NSW RURAL FIRE SERVICE

Your Ref: MP08_0005 MOD 1
Our Ref: D18/5168
DA18041212621 AB

Agency Comment: Part 3A/State Significant Development Modification Application - Lot 106 DP 1144462; The Pines Caravan Park, 8 Hearnese Lake Road, Woolgoolga

drawing title The Pines Concept

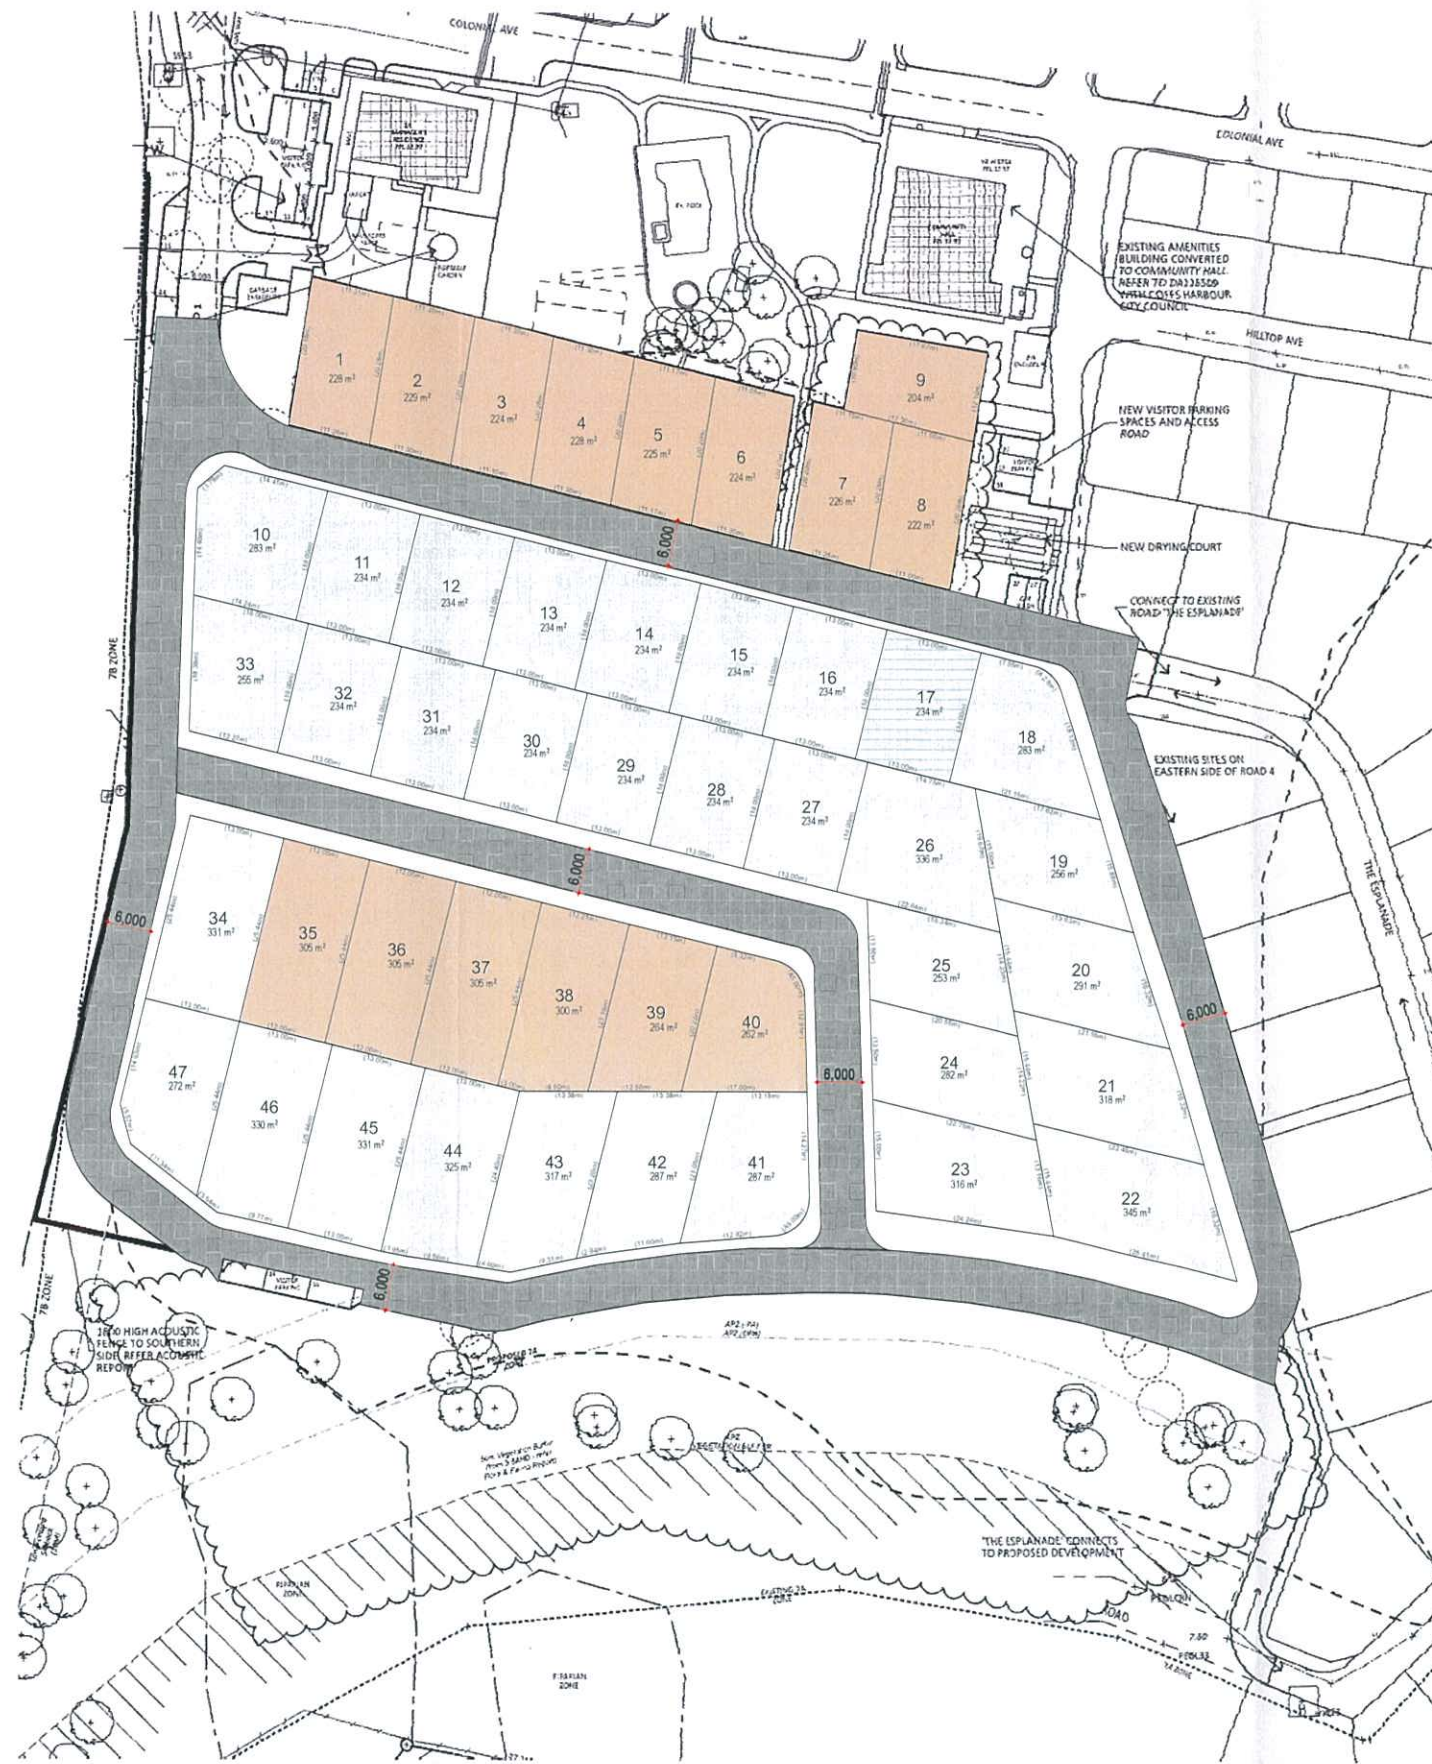
1. At the commencement of building works and in perpetuity the property to the south or proposed Lots 22-23 and 41-47 to a distance of 30 metres, shall be maintained as an asset protection zone (APZ) as outlined within section 4.1.3 and Appendix 5 of 'Planning for Bush Fire Protection 2006' and the NSW Rural Fire Service's document 'Standards for asset protection zones'. (Note: in forested areas a portion of the APZ may be maintained as an
